TOWN AND COUNTRY PLANNING ACT 1990 FULL

Reference: H16-0086-24 **Date of Decision:** 27th March 2024
Applicant: Mr J & Mrs E Duda
Coneygarth
Cowbit Road
Spalding
Lincolnshire
PE11 2RJ
Location: Coneygarth Cowbit Road Spalding
Description: Front & side first floor extensions & alterations

South Holland District Council hereby give notice that this application has been REFUSED for the above proposal for the following reason(s):

Project address: Coneygarth, Cowbit Road Spalding PE11 2RJ		
Drawing: Plans & Elevations Proposed		
Scale: 1:100@ A1	Drawn By: A.J.	Drawn date: January 2024
Drawing No: 24-018 - P004	Revision:

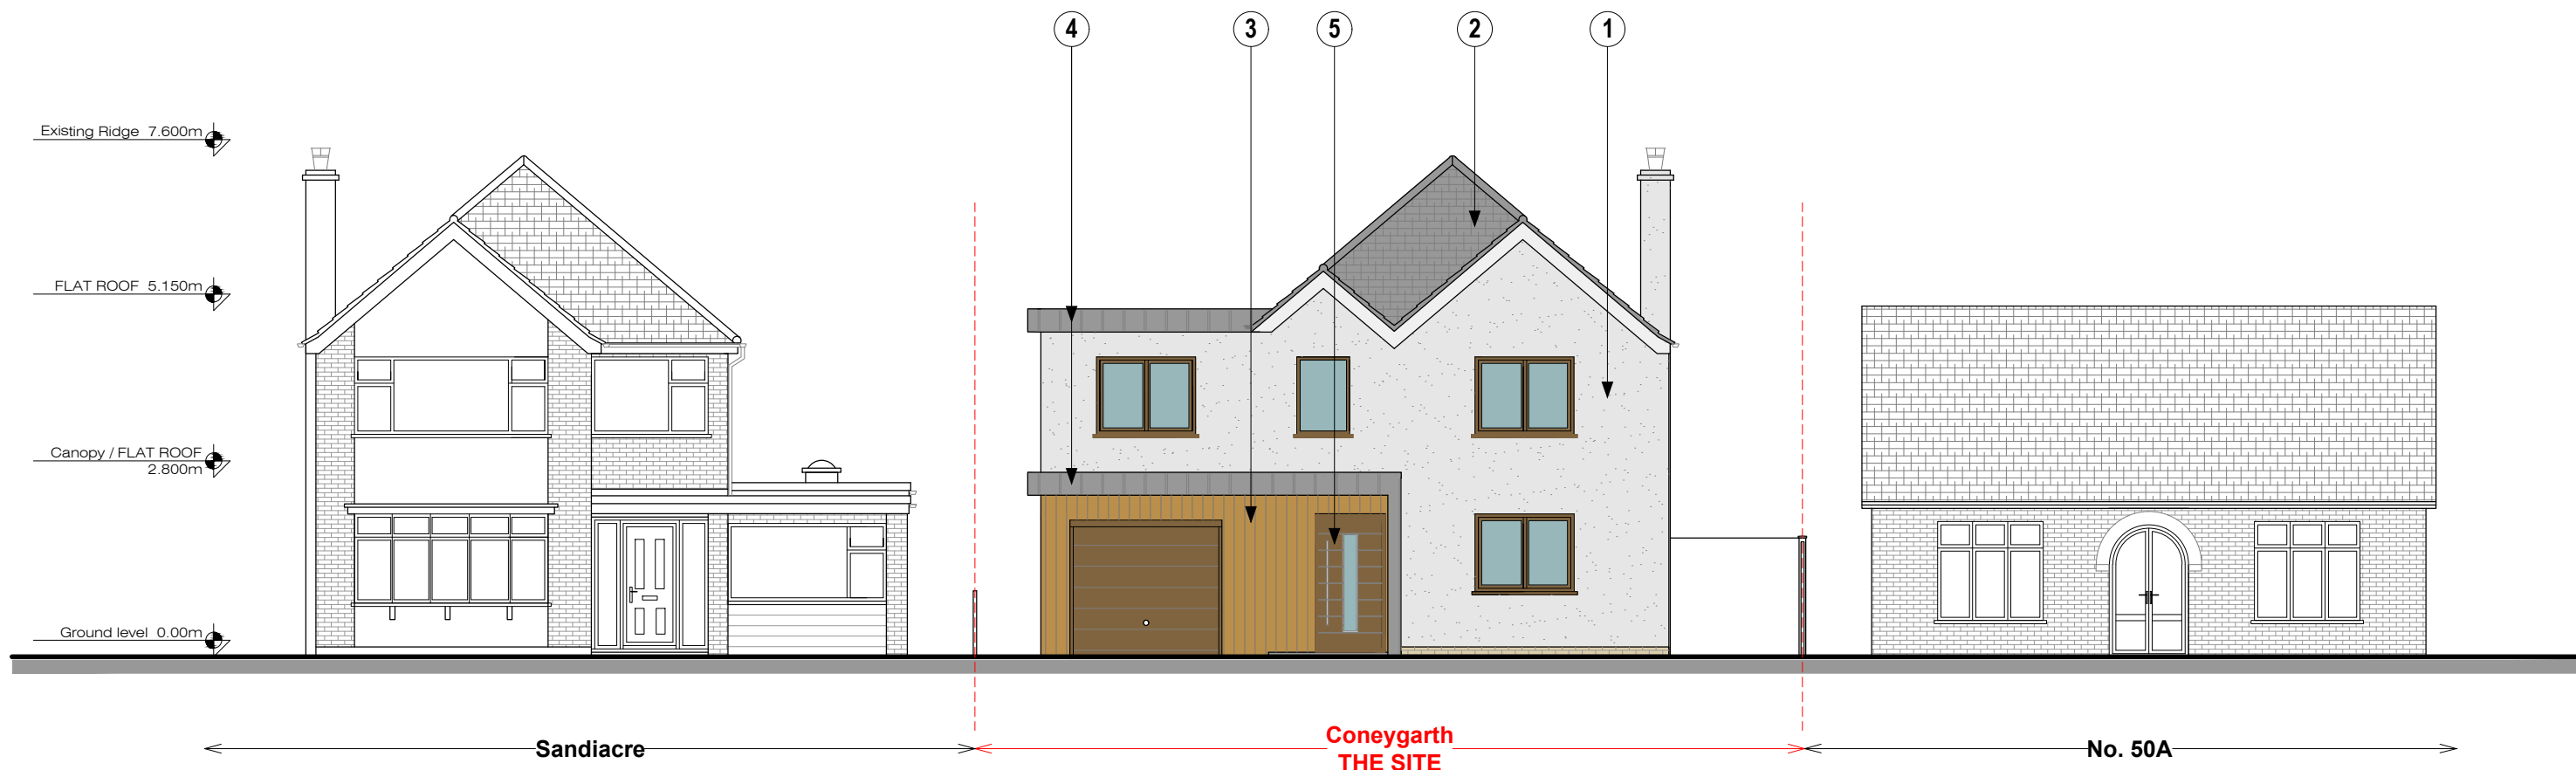
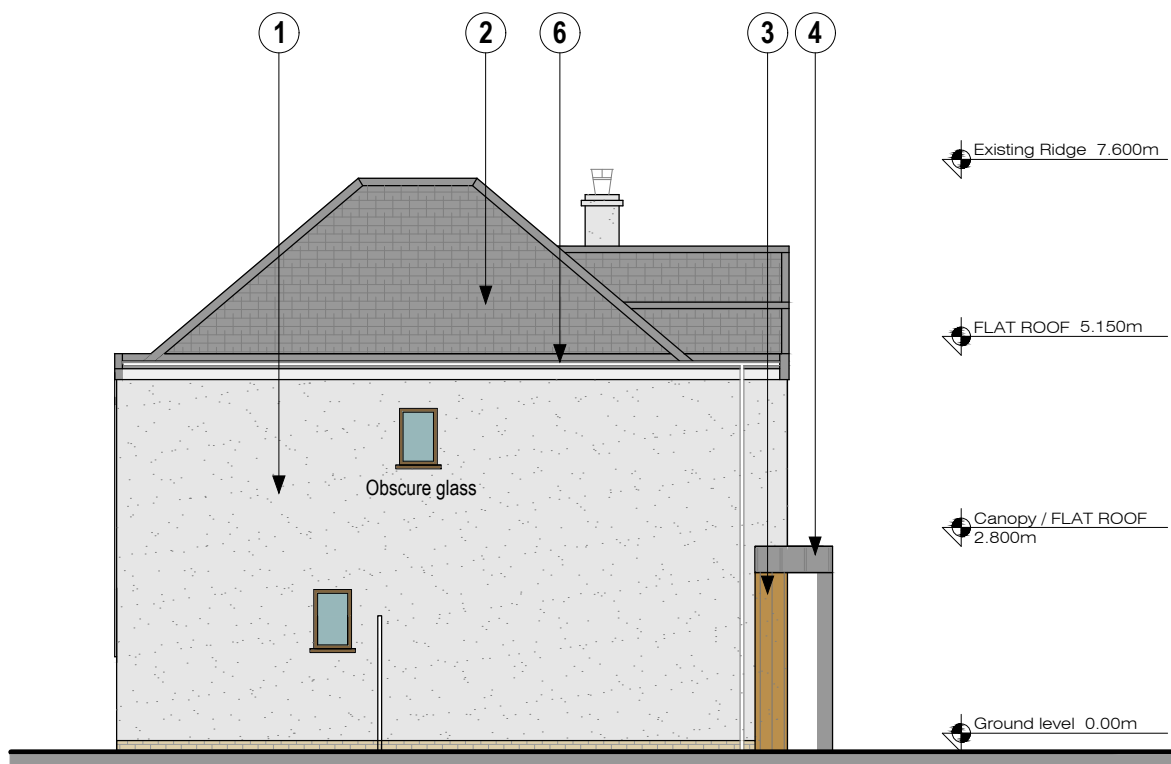
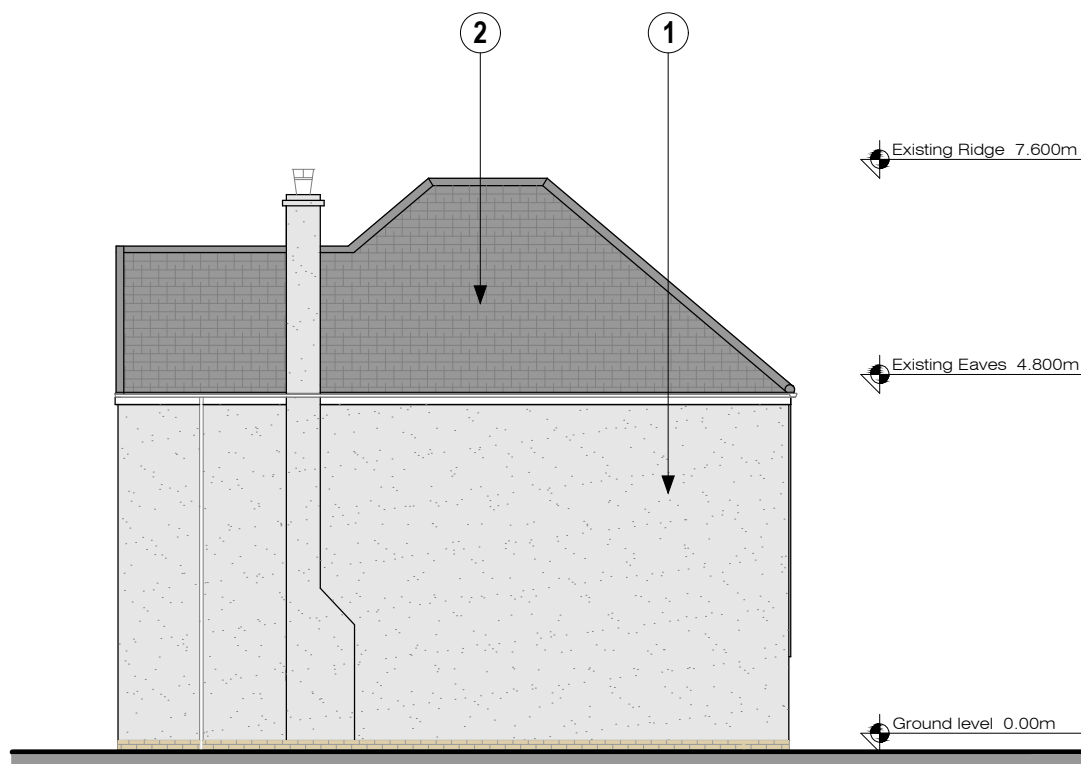
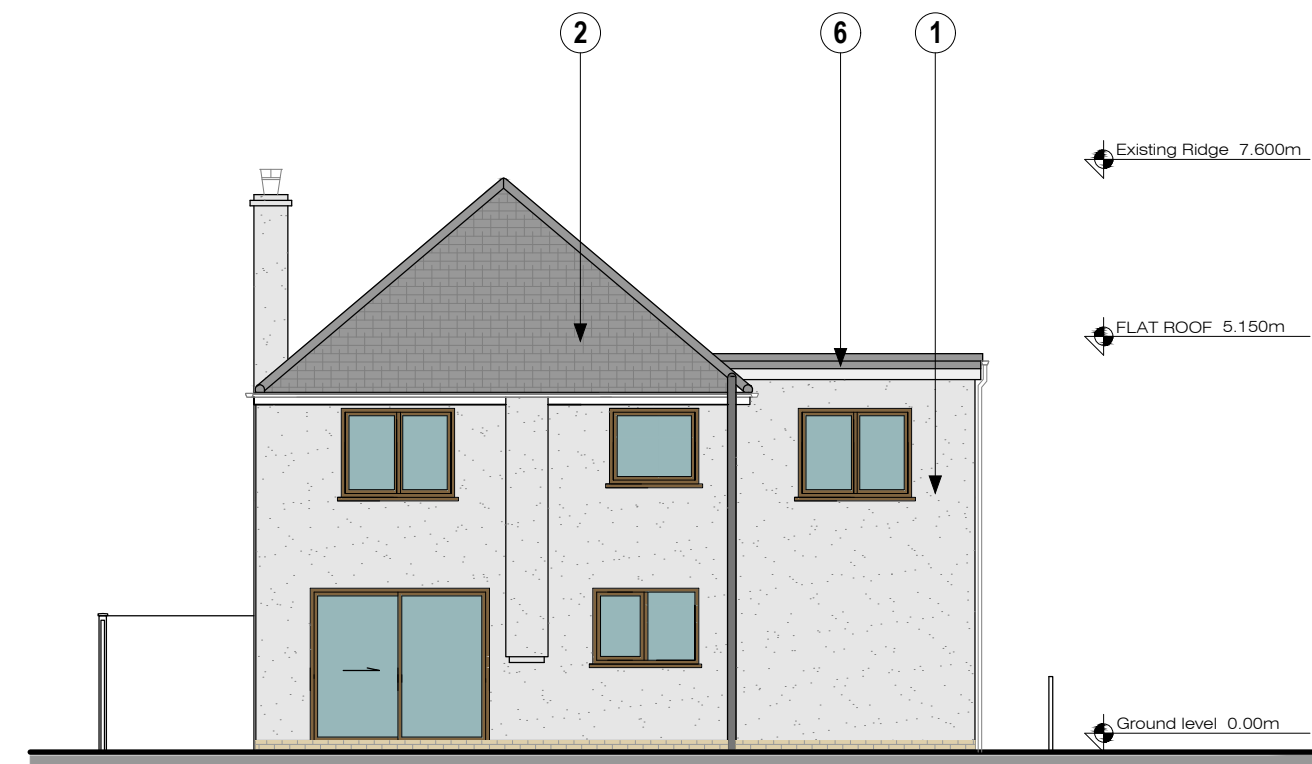
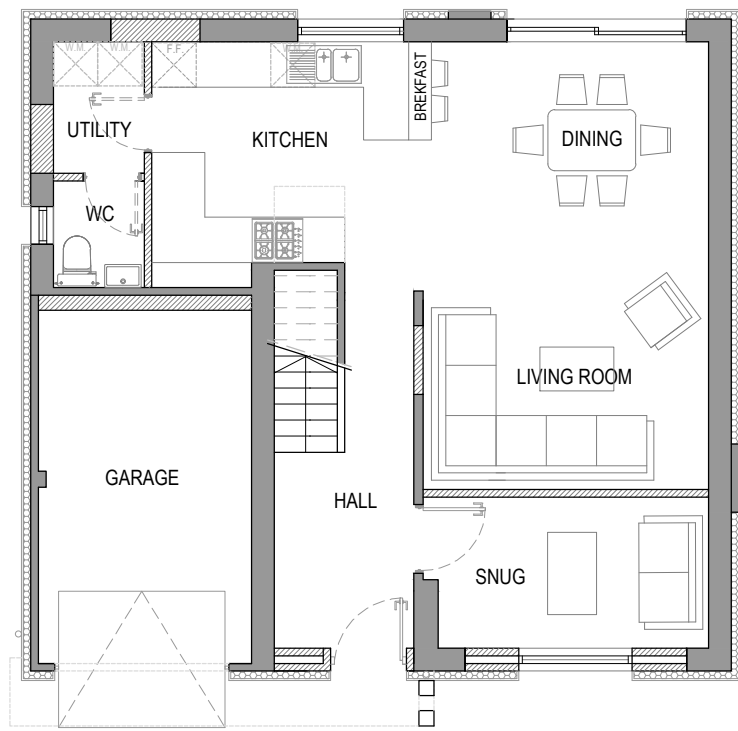
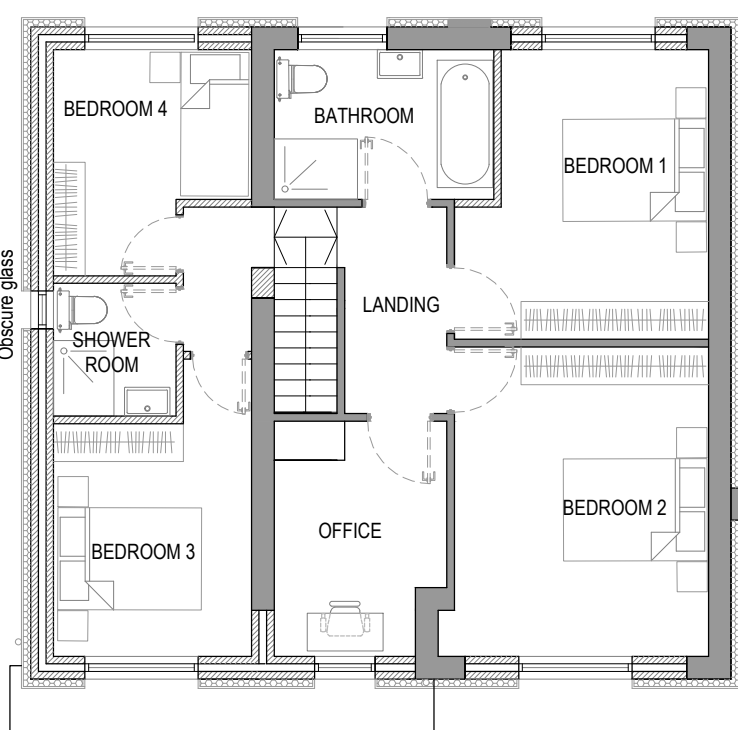
- 1 The proposed extension by virtue of its scale, appearance and general design, would give rise to unacceptable character impacts to both the host dwelling, Coneygarth, and the wider street scene. The addition of a first floor flat roof extension would represent an unduly dominant, obtrusive and alien feature within the street scene which fails to reflect the prevailing character of the setting.
